Application No: K/11/22/PL
Site Address: Salamanda 37 Coastal Road Kingston BN16 1SJ
Description of works: Demolition and erection of 1 No detached dwelling. This site is in CIL Zone 4 and is CIL Liable as new dwelling.

Thank you for your internet representation made on 31st March 2022 which has been recorded as an objection with the comments as follows:

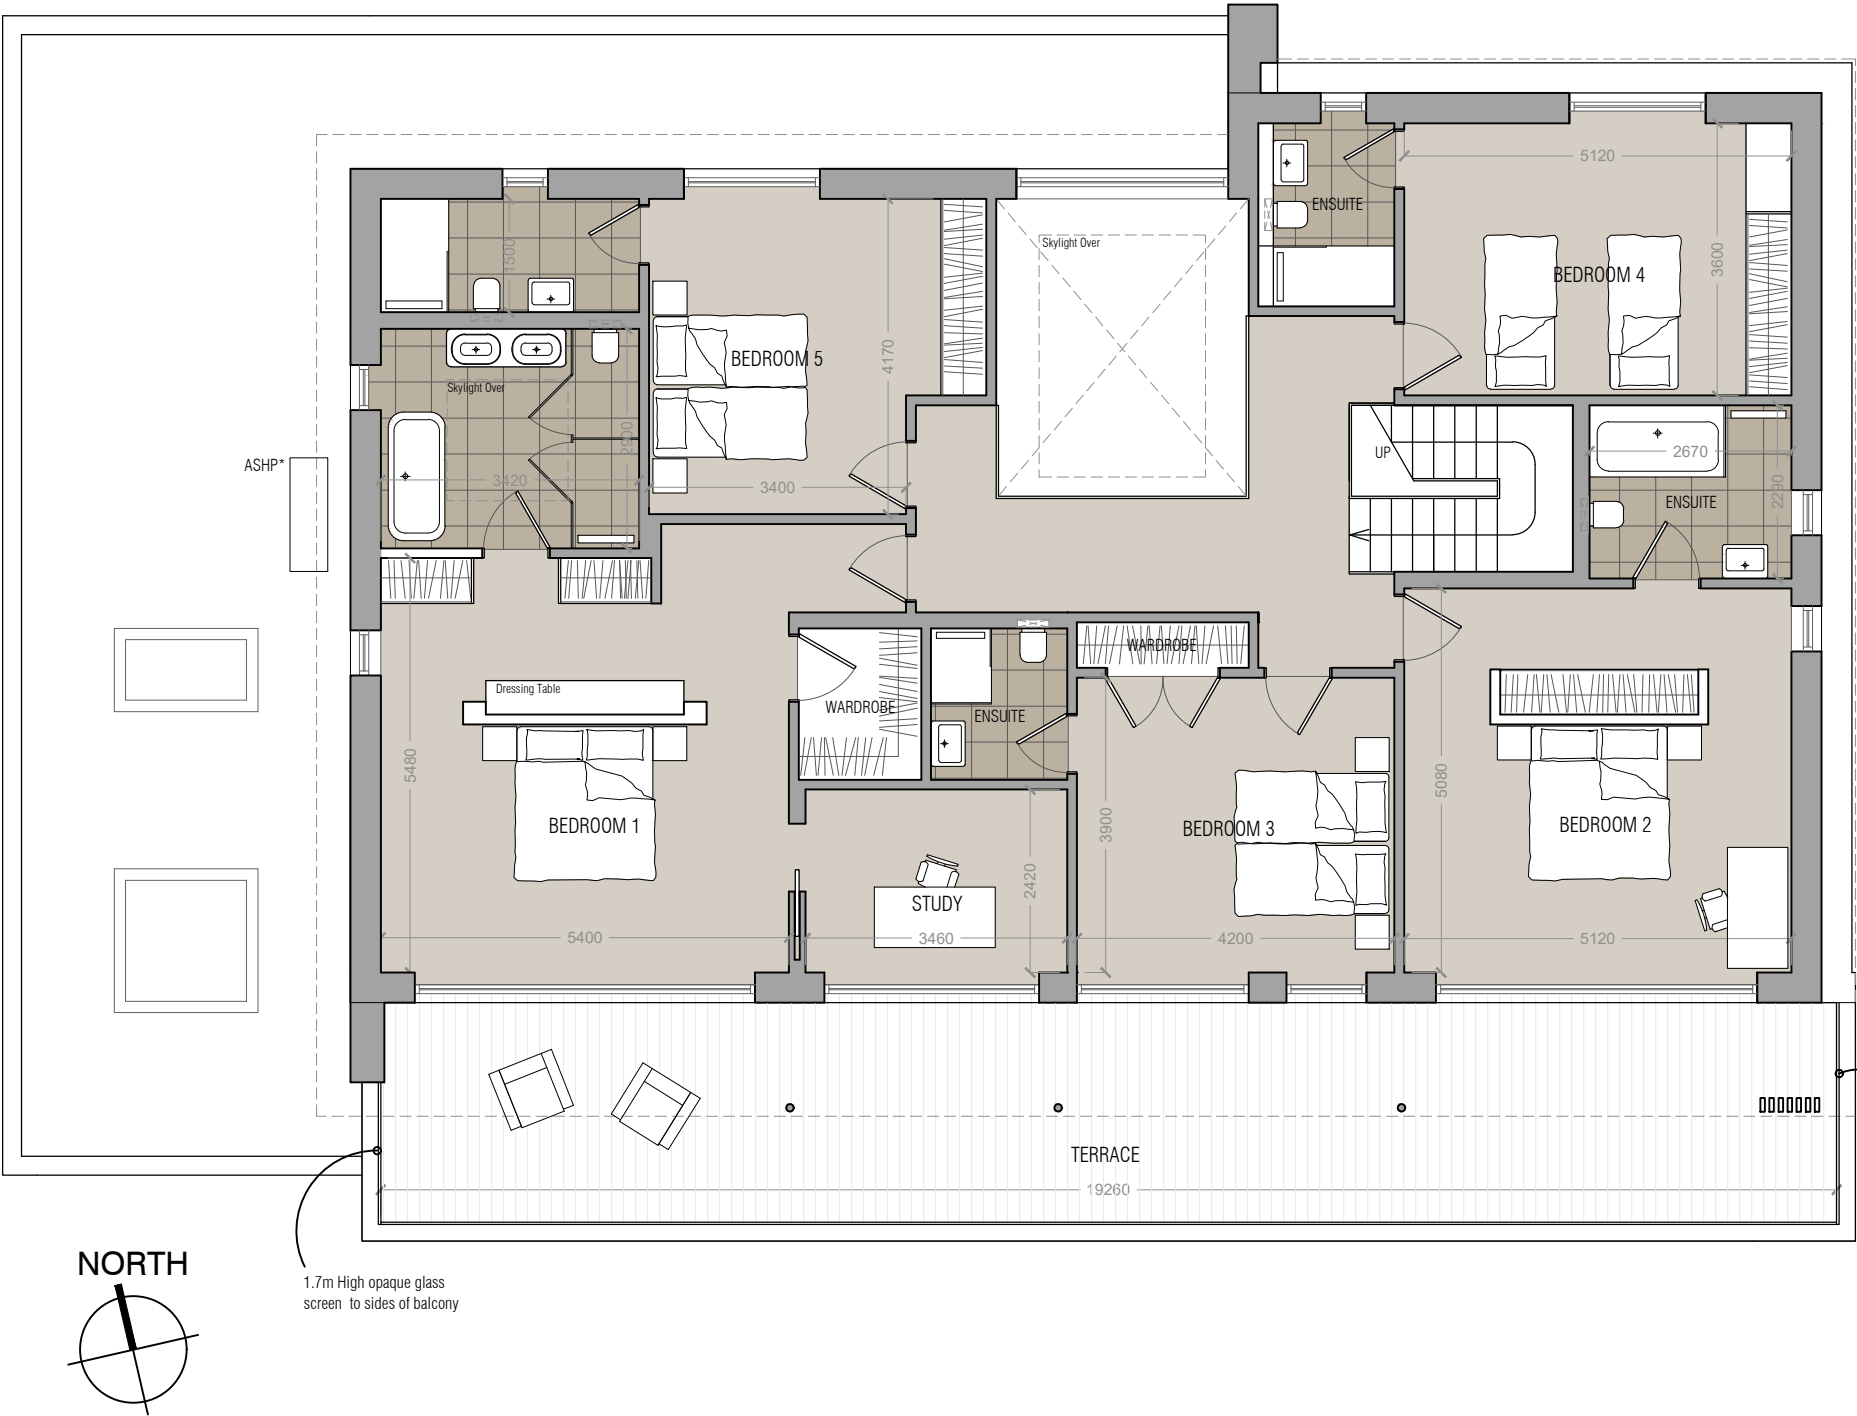
1. The first-floor balcony should be properly screened from both sides
2. The roof terrace should be removed due to privacy, amenity and subsequent visual impact grounds
3. The solar panels, and AC plant should be better sited, integrated and screened
4. The swimming pool and associated plant room should be better sited to the footpath side of the property.
